**Rezoning Transportation Analysis**  
**Petition Number: Insert Zoning Petition #2021-056**  
*General Location Identifier: 04105416*

**Revision Log:**

| Date       | Description        |
|------------|--------------------|
| 10-18-2021 | Fourth Review (WB) |

The site is located on a City-maintained local road (B Avenue), east of Beatties Ford Road, a City-maintained major thoroughfare. There is unmaintained right-of-way adjacent to the site where a new public roadway (C Avenue) will be constructed. Site plan revisions are needed to meet ordinance requirements and the outstanding items including, but not limited to dedicating public right of way and constructing improvements for new public streets, implementing sidewalk and accessible ramps, and adding standard CDOT conditional notes. Further details are listed below.

Drawing No. **RZ-1.0**

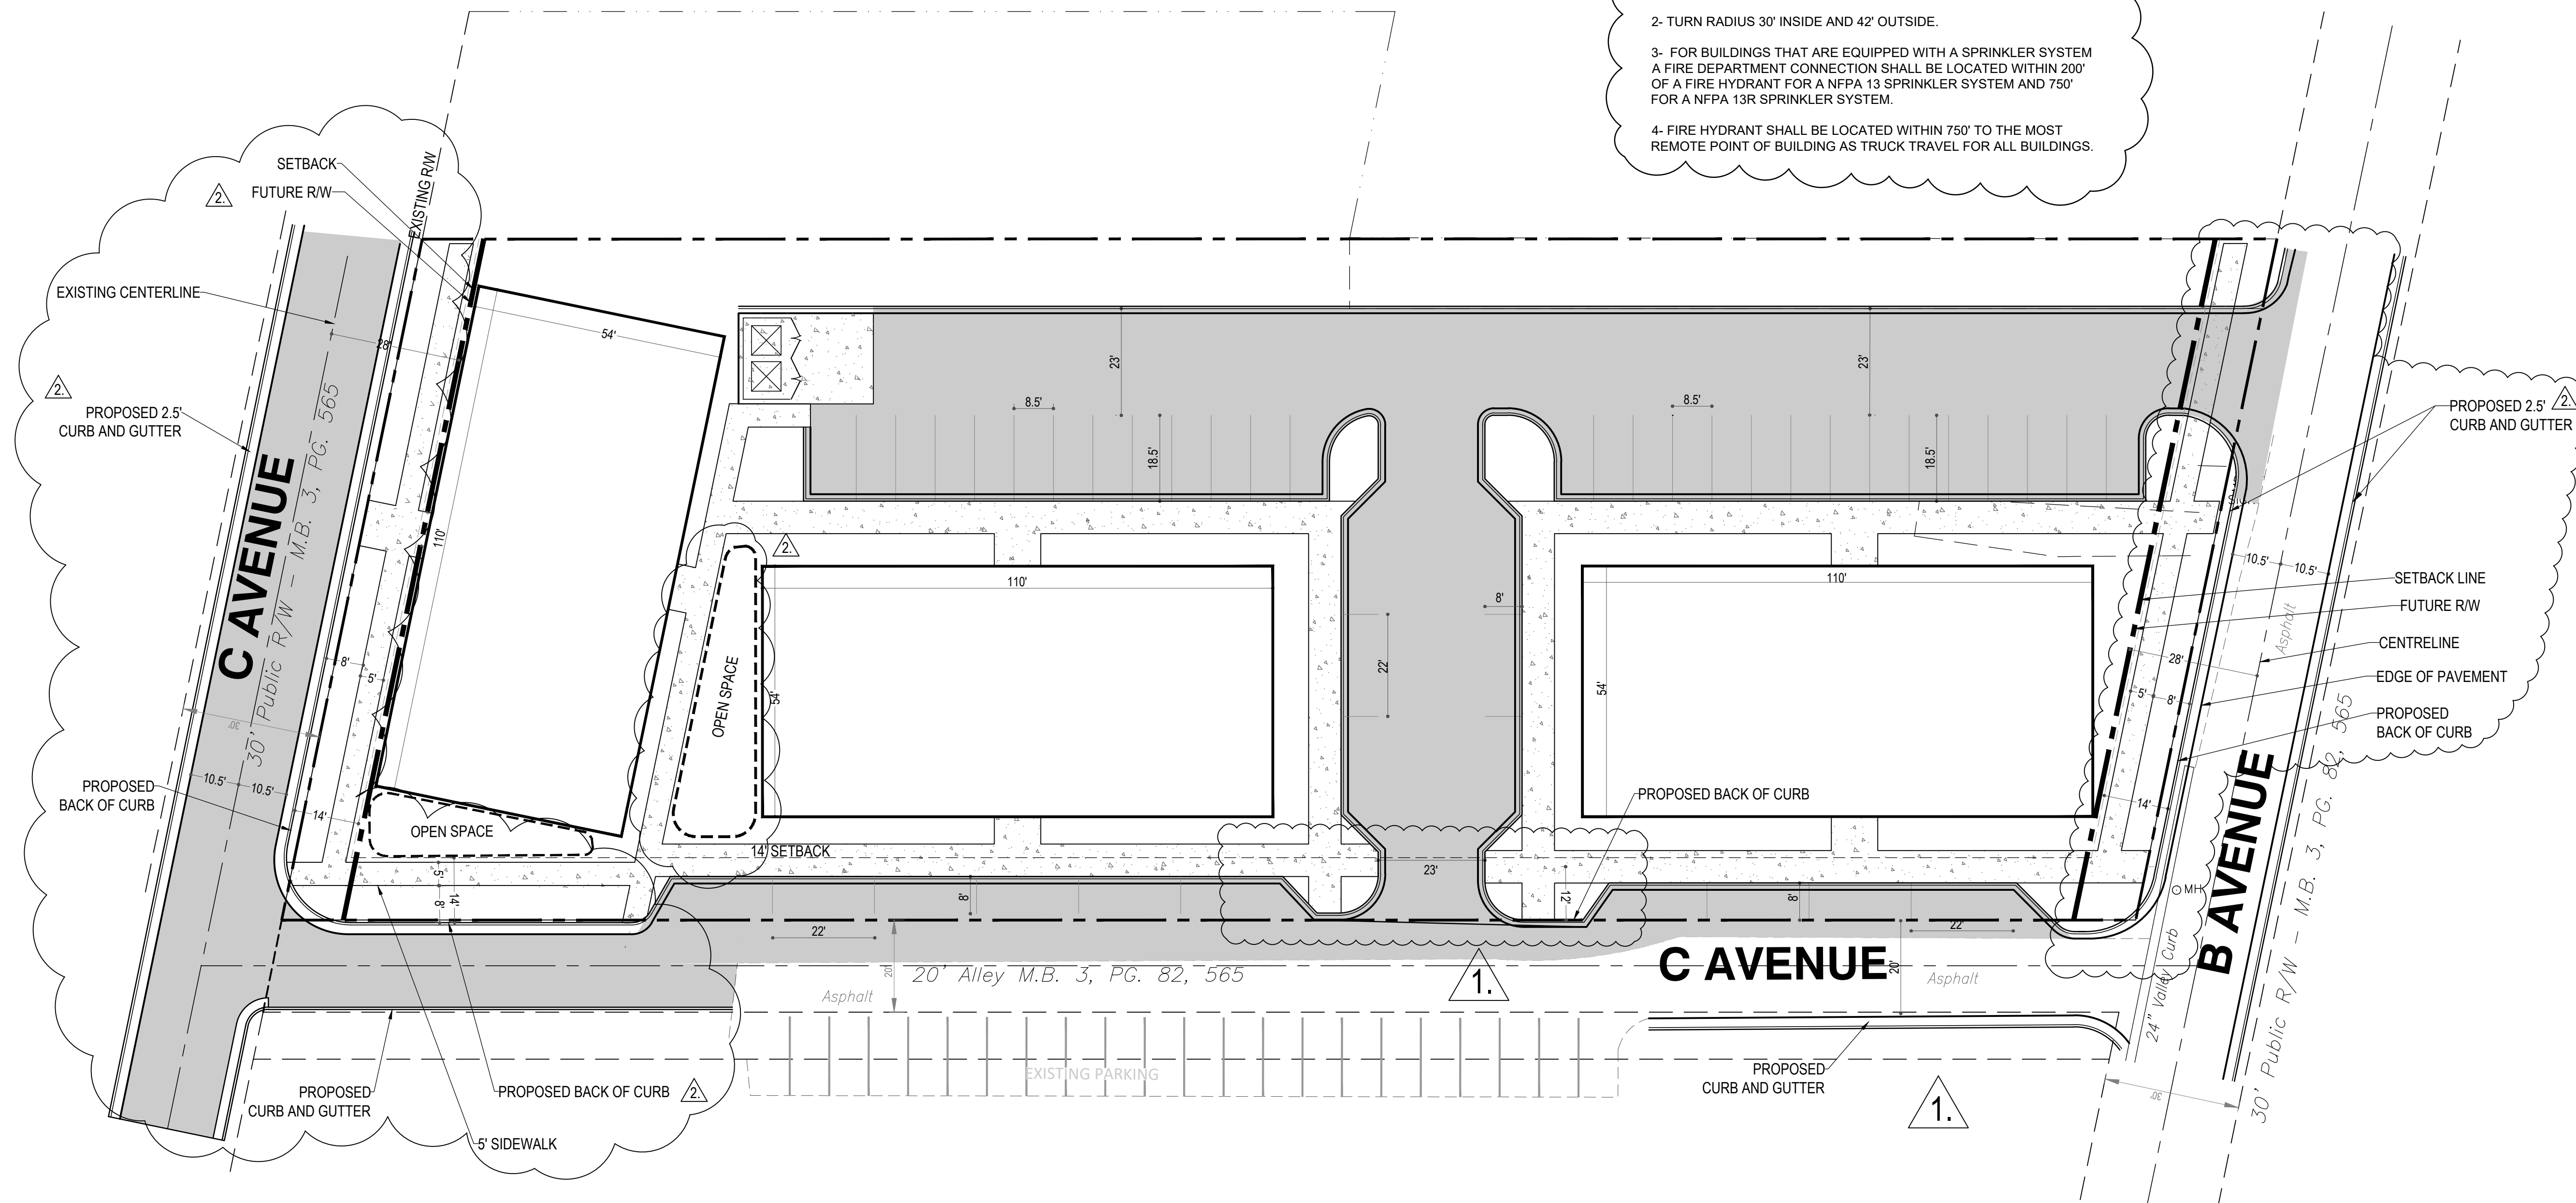
- b. **C Avenue (east-west street formerly labeled as North Avenue):** Construct a CLDSM standard detail number U-02 – Local Residential Medium Street Typical Section (for the portion highlighted in red) along the property frontage of North Avenue.

**Outstanding Comment: New Comment as a Result of 08-16-2021 Site Plan:** Planting strip and sidewalk is only required along this rezoning site's property frontage. This planting strip and sidewalk needs to be shown along C Avenue on rezoning sheet RZ-1.0. 8-foot planting strip and 8-foot sidewalk is only required along this rezoning site's property frontage since DUA is greater than 12.

- c. **Outstanding Comment (revised on 10/18/2021 based on updated site plan): Paper Right of Way (Labeled as Alley/ C-Avenue):** Construct a CLDSM standard detail number U-03 – *Local Residential Wide Street Typical Section* (for the portion highlighted in blue) along the property frontage of alleyway/paper right of way. 8-foot planting strip and 8-foot sidewalk is only required along this rezoning site’s property frontage since DUA is greater than 12.

Label and dimension the curb and gutter and proposed right of way from the centerline for each road on the site plan.

3. **Outstanding Comment:** Revise site plan and conditional note(s) to commit to dedicate 35.5-feet of public right-of-way from the alleyway centerline, if public right of way is already platted. The site plan shall label and dimension the right-of-way from the road centerline, per CLDSM standard detail number U-02 – *Local Residential Medium Street Typical Section*.

*U-03 – Local Residential Wide Street Typical Section.* If this is confirmed to only be a 20-foot wide alleyway, coordinate with CDOT to determine the appropriate requirements.

4. **Outstanding Comment:** Revise site plan and conditional note(s) to commit to construct an 8-foot planting strip and 8-foot sidewalk on all public street frontages per Chapter 19 / Chapter 20 of the City Code and the Charlotte WALKS Council-adopted policy. 8-foot sidewalk is needed since more than 12 dwelling units per acre is proposed.
5. **Outstanding Comment:** Revise site plan and conditional note(s), including Site Plan Conditional Note 3.a, Access, Transportation, and Improvements to extend the Residential Wide typical section on the alleyway / paper right of way to (east-west) C Avenue (now labeled as C Avenue).

6. **Outstanding Comment:** Revise site plan and conditional note(s) to commit to construct two PROWAG ramps at the alleyway / paper right of way intersections with North Avenue (now labeled C Avenue) and B Avenue (**Comment clarification on 10/18/21** – two ramps per corner).

7. **Outstanding Comment:** A site plan note(s) specifying dedication and fee simple conveyance of all rights-of-way to the City before the site's first building certificate of occupancy is issued is needed. CDOT requests rights-of-way set at 2' behind back of sidewalk where feasible.
8. **New Comment (revised on 10/18/2021 based on updated site plan):** Petitioner to meet with CDOT staff on 10/21/2021 to discuss transportation requirements as part of this petition. Further comments may be added pending the outcome of that discussion.
